12 December 2013

**NSW Government
Department of Planning and Infrastructure**

CBD and South East Light Rail Project - Comments on EIS exhibition

Figure 5.25 Section thru proposed Moore Park stop

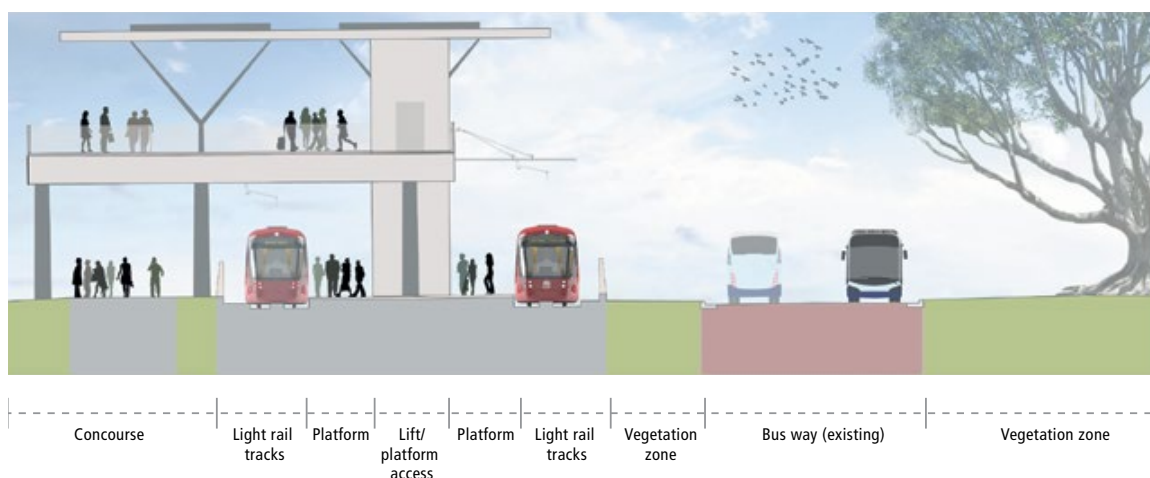
3.1 The park stop typology defined in section 4.1 is supported. However, the intent of minimising visual impact does not seem to be reflected in the initial designs presented for the Moore Park stop. The proposed design of the Moore Park stop as a two storey structure with vertical lift access has a significant impact on the visual amenity of the Park and is not supported. A single storey structure or minimal lightweight means of delivering passengers onto the central platform is to be considered. The stop requires appropriate design and construction in consultation with the Trust's heritage guidelines given its prominent location.

It is suggested that crowd control during events is managed in a manner that does not require a 2 –storey structure. It is noted that the Royal Randwick Racecourse stop which is also used for special events is designed as a single storey structure.
